Your Ref: 2024/93485
Our Ref: A005994

16th January 2025

Shaw Cross House, Shaw Cross Business Park, Shaw Cross, Dewsbury – Discharge of details reserved by condition 10 (Public Sewerage Infrastructure) on permission 2023/93273 for erection of two storey rear extension and extension to car park

Section (1-1) Through Foundation Existing Drainage

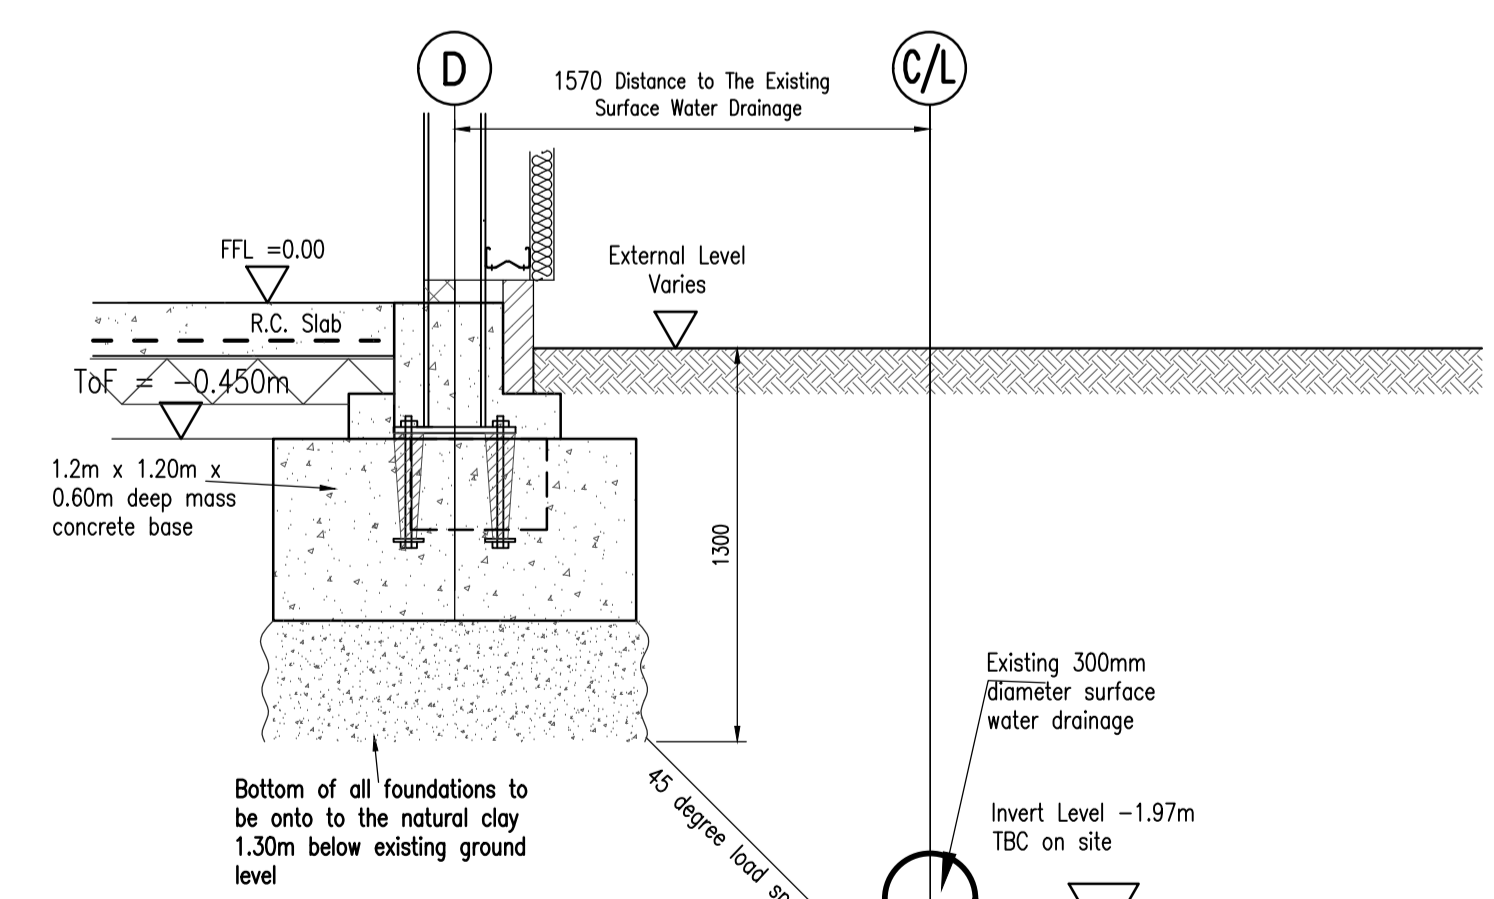
Drawing KS507/F01 (Rev B) dated 24/11/2024 prepared by Kryton Structures shows sections 1-1 where the 45 degree load spread originates from the footing base. Section 2-2 shows the 45-degree load spread originates from the clay below the footing, otherwise it appears the load would be applied to the 300mm diameter public surface water sewer in close proximity. Clarification is required.
